Our Ref: 09-374 GC:BL
Your Ref: DA09/0701.03 LN 35979

26 July 2018

Altitude Aspire Estate
MP09/0166 MOD 3
(Council Ref DA09/0701.3)
RFI Response to letter 11 May 2018

NEWLAND DEVELOPERS PTY LTD	
TERRANORA PRECINCT 1 CENTRAL OPEN DRAIN SWALE PLAN	
09-374 21.09-2017	SK3618 REVISION E

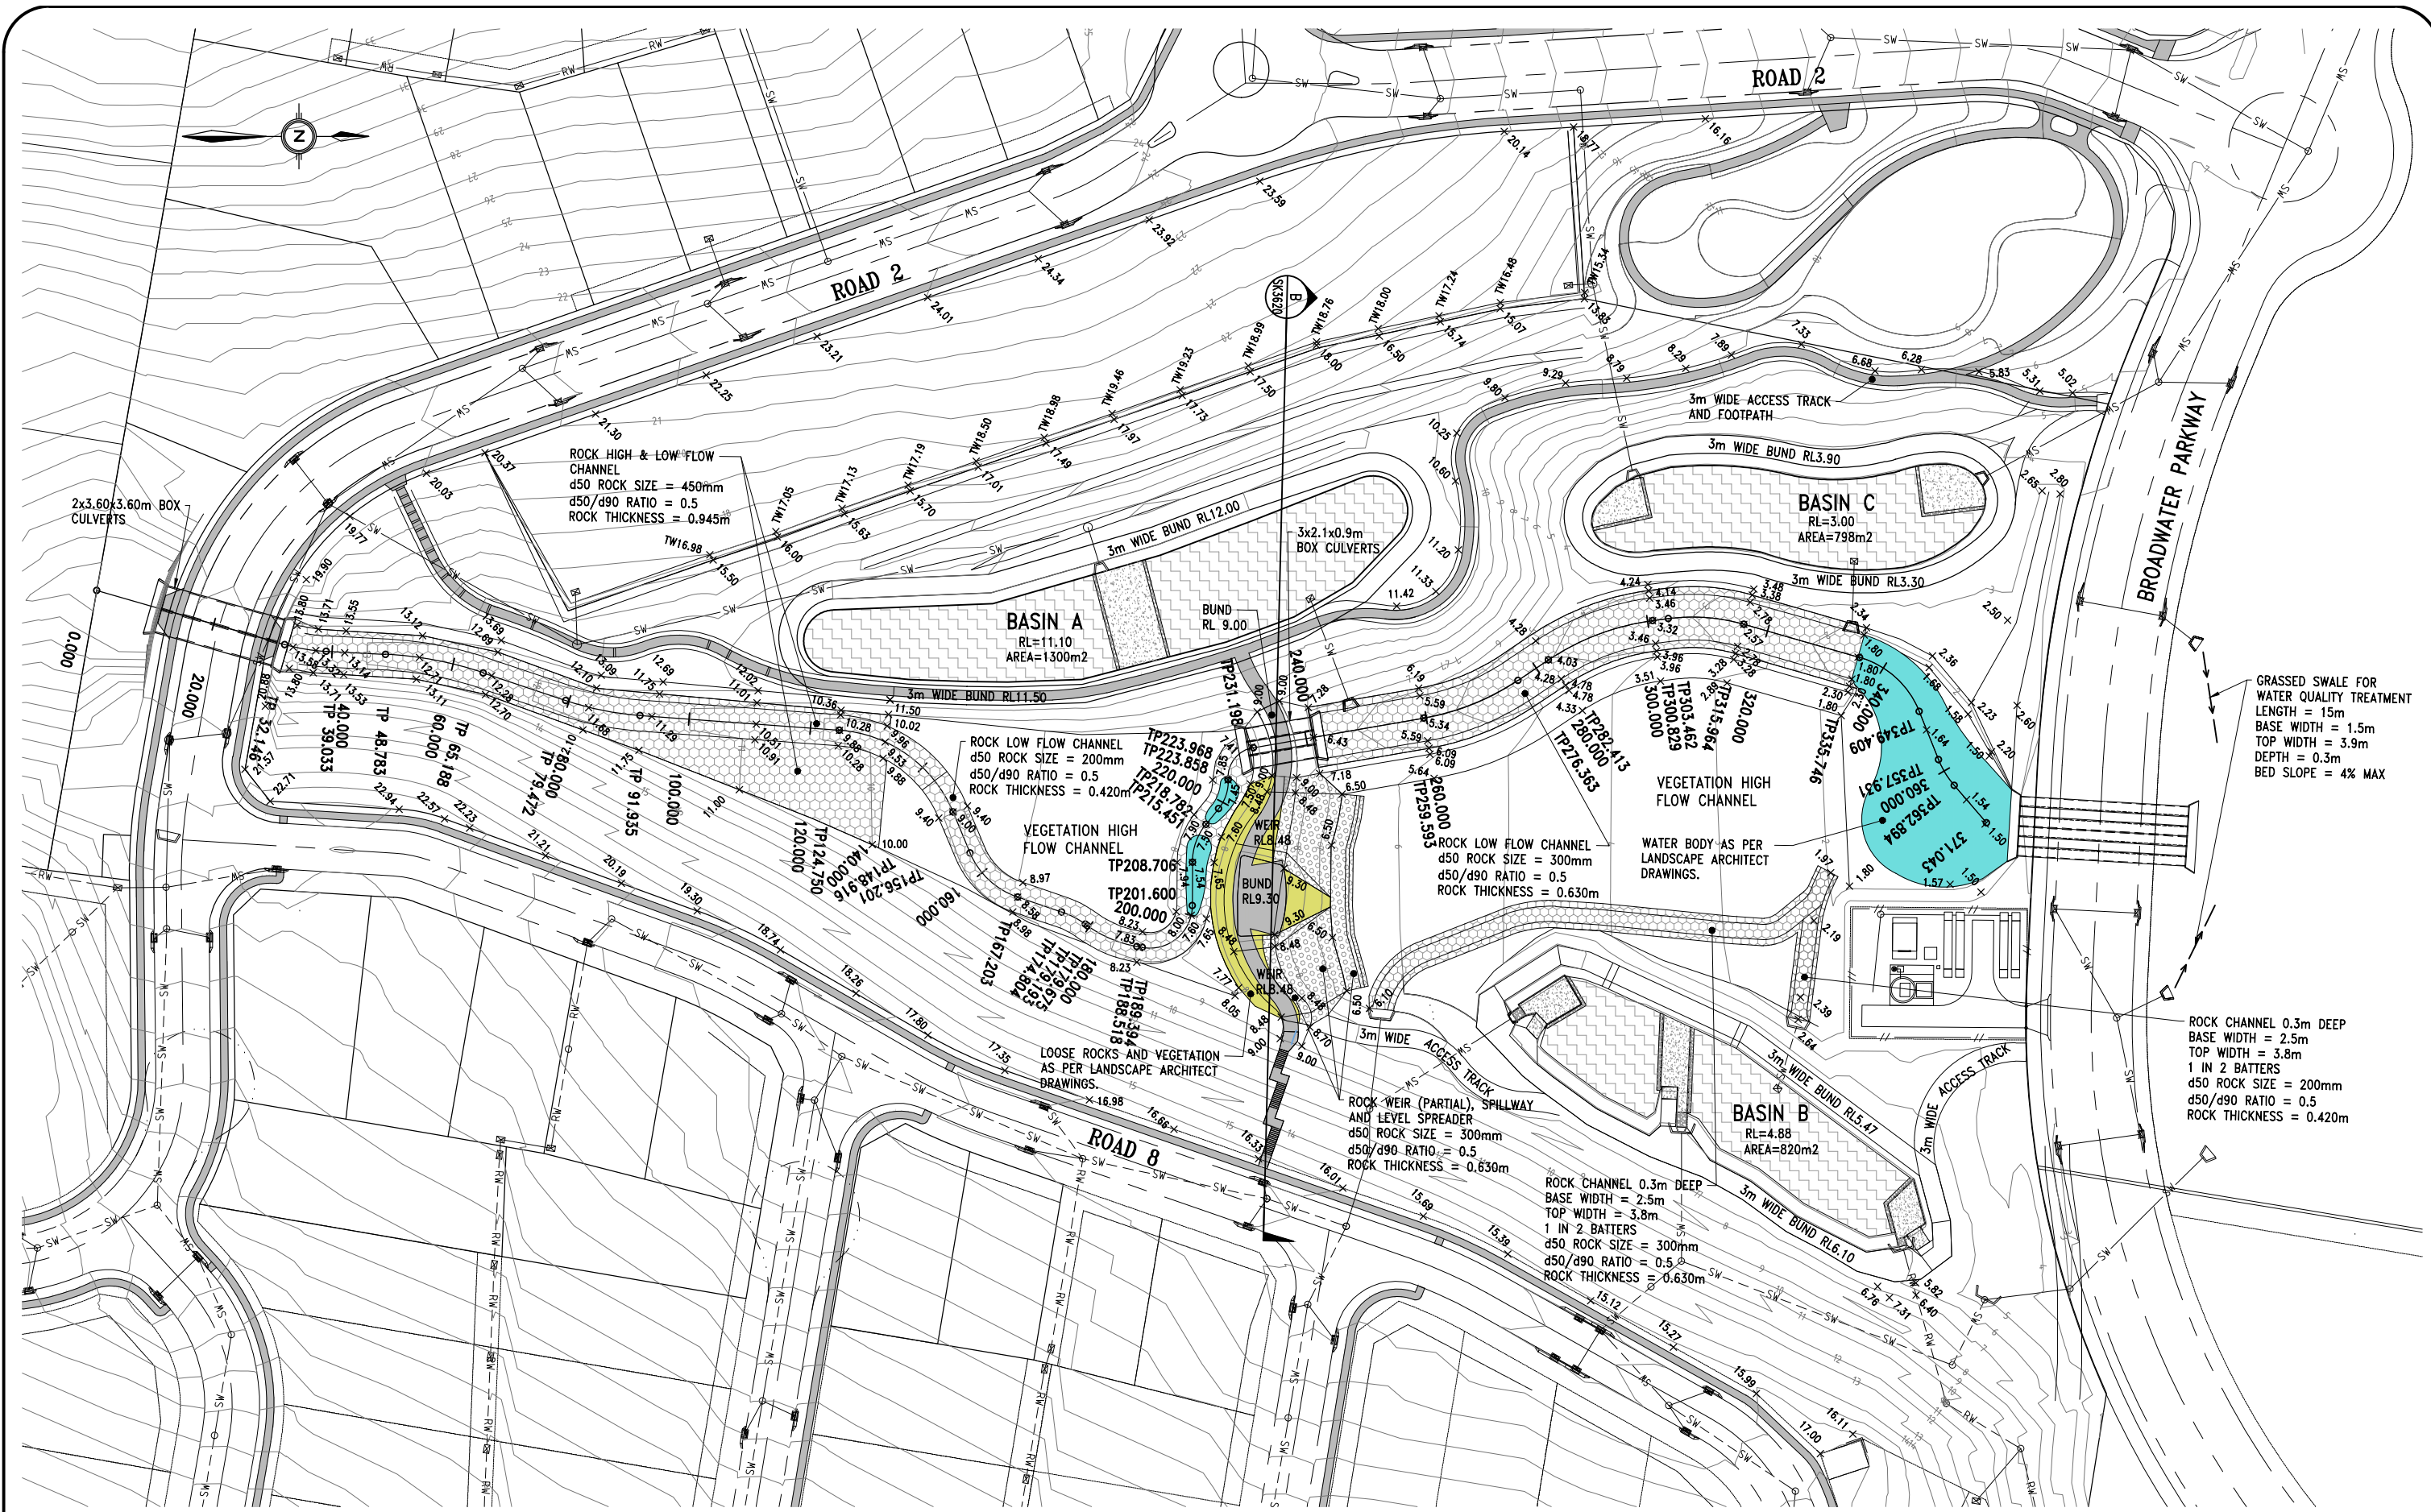
- e) Maintenance accessibility is provided with 3m wide access tracks as shown on drawing SK3618 sheets 1, 2 and 3. The access tracks enter off Broadwater Parkway and provide direct access for maintenance to each of the bio basins.

The Maintenance Access tracks also provide access to the central drainage channel at strategic locations for maintenance, with the provision of "turn-a-round" areas for small maintenance vehicles, at which point it is envisaged maintenance will be carried out "on foot".

Typically, cross sections between chainage 30 and chainage 190 (approx.) are about 6m wide with flat "berm" sections either side for foot traffic to carry out maintenance. We would anticipate one maintenance worker each side of the channel in this section, each with typically "knapsacks" strapped to their back and spraying weed killer, if necessary, as they go. The maximum distance for each of the maintenance workers on foot is approximately 70m between chainage 30 and chainage 100. Elsewhere the distance for "foot traffic" maintenance is approximately 30m and cross sections have flatter slopes either side and the channel corridor section widens to approximately 10m between the Boardwalk and Broadwater Parkway.

SK3623
REVISION D

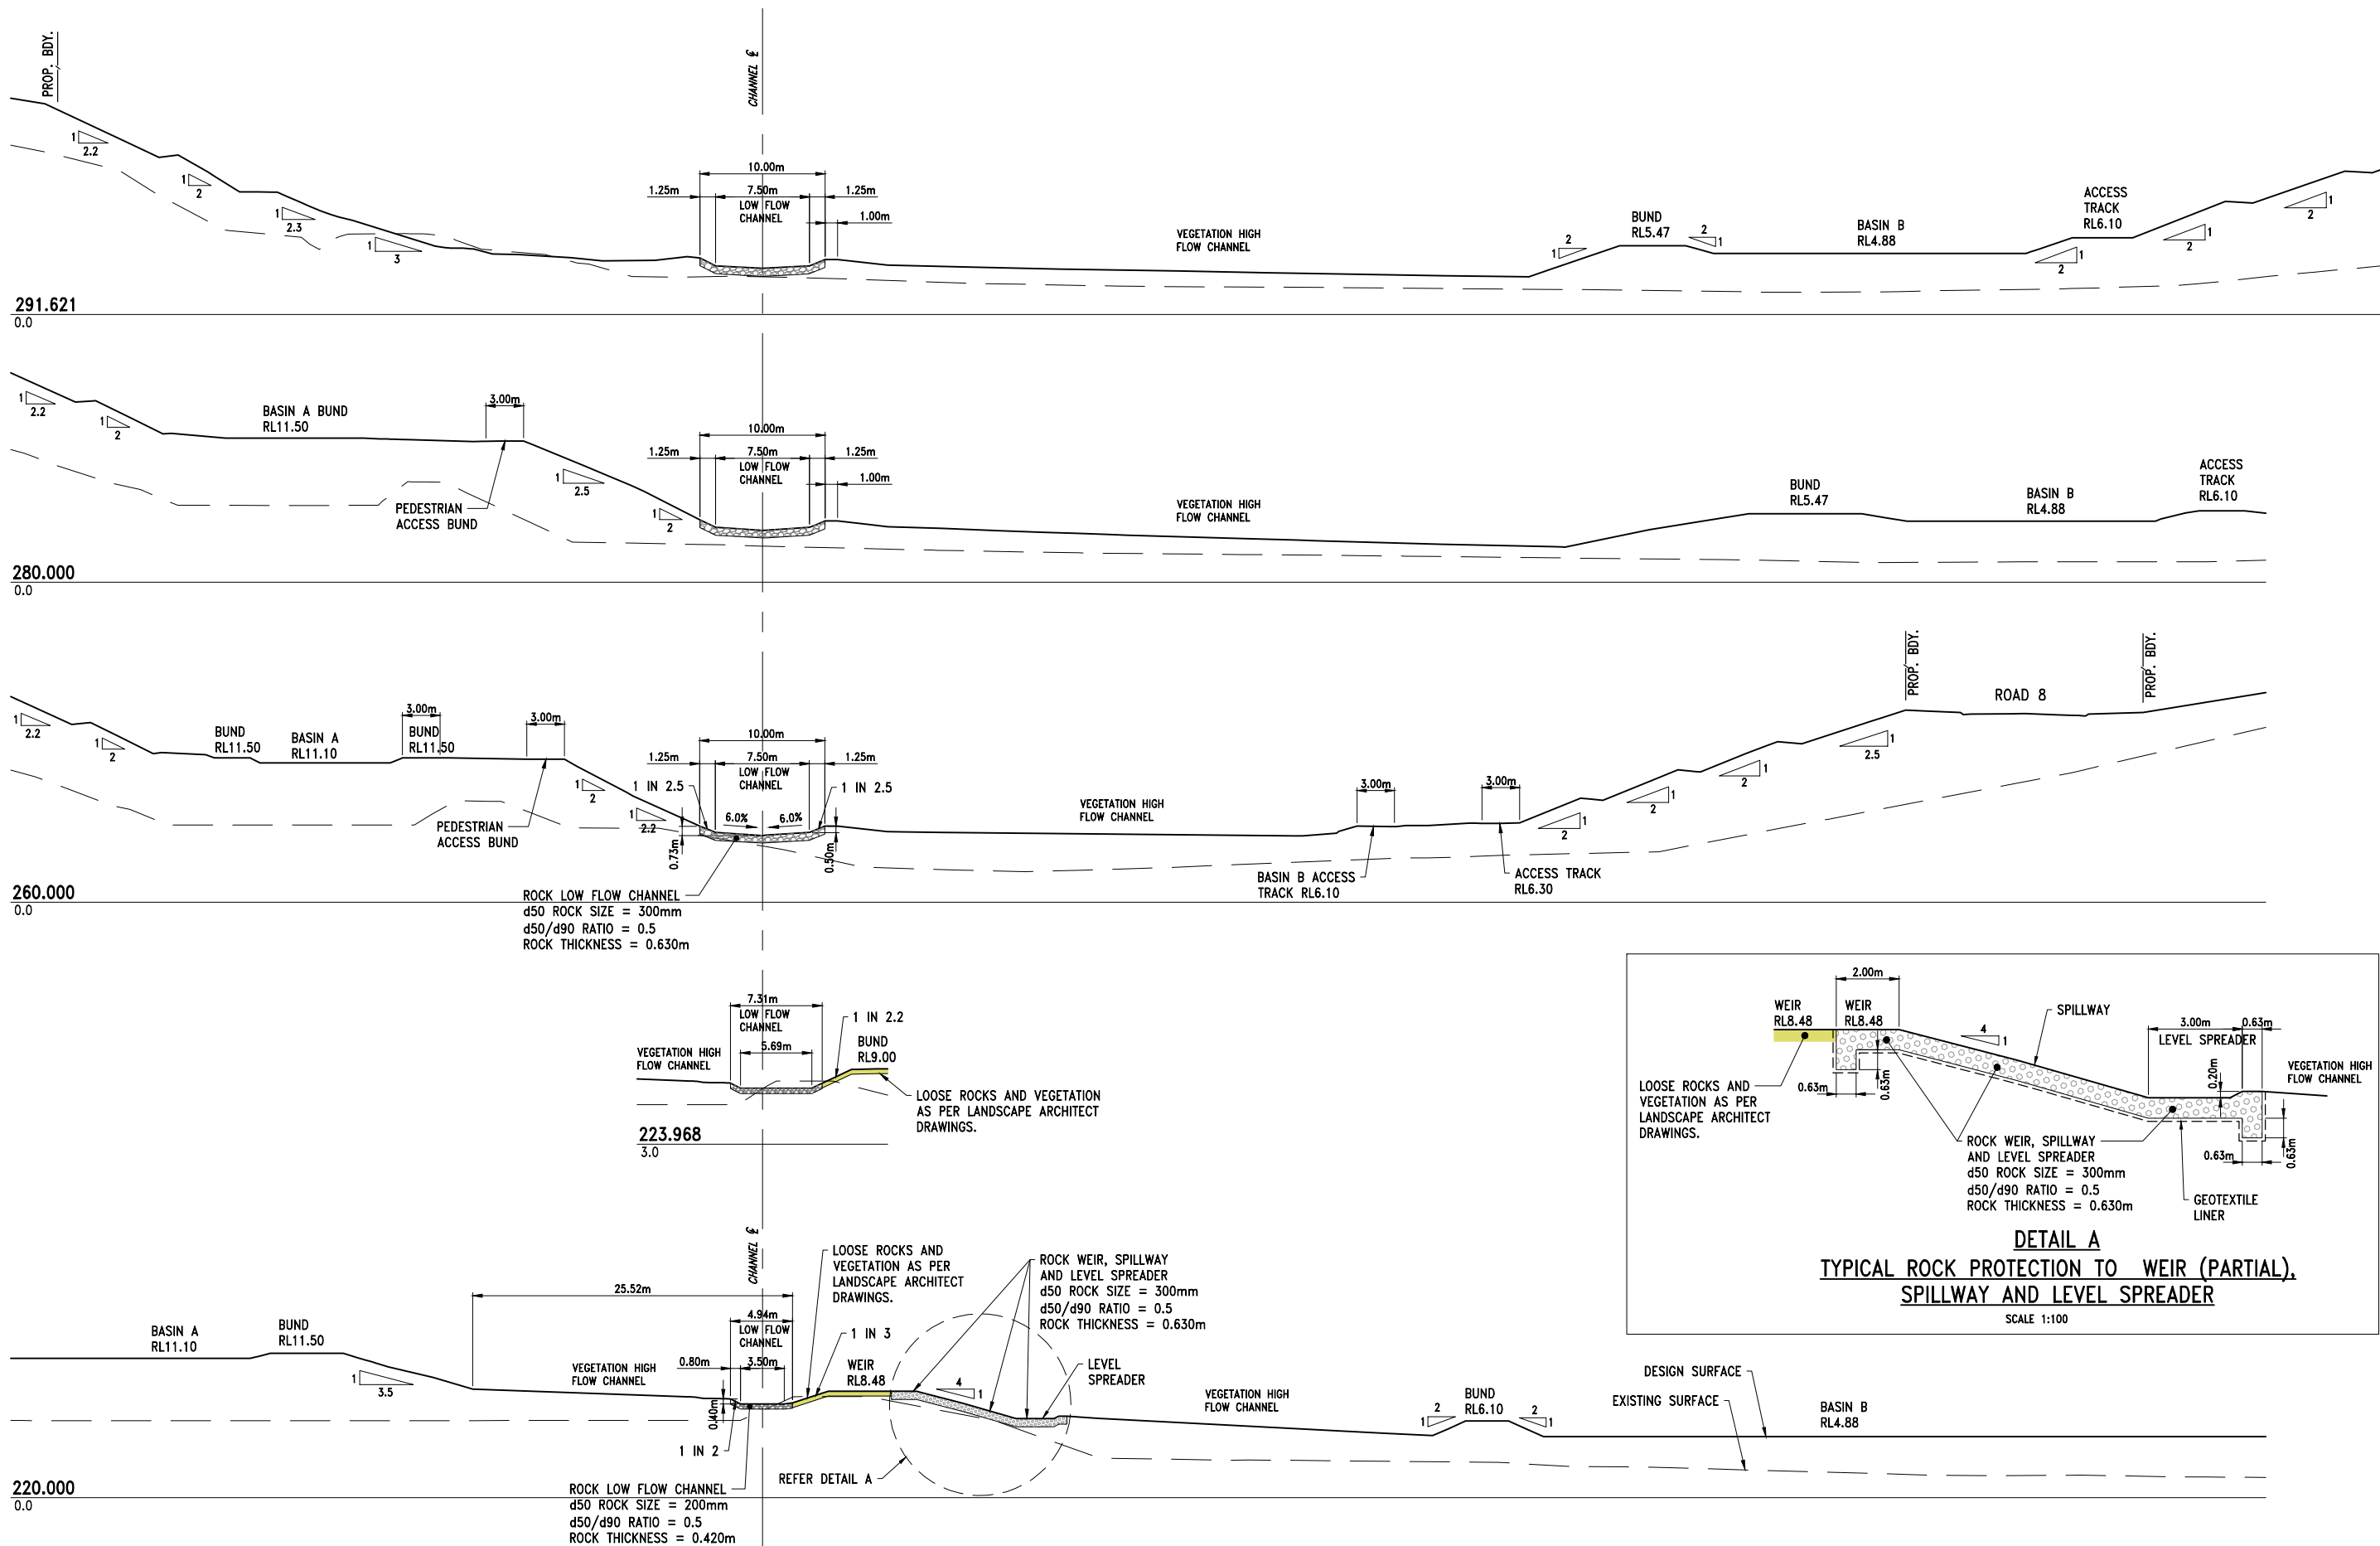
- c) Batter slope variability has been amended to reflect more closely Council concerns – refer long section drawing SK3619 Rev D and cross section drawings SK3620 Rev E to SK3625 Rev E inclusive.
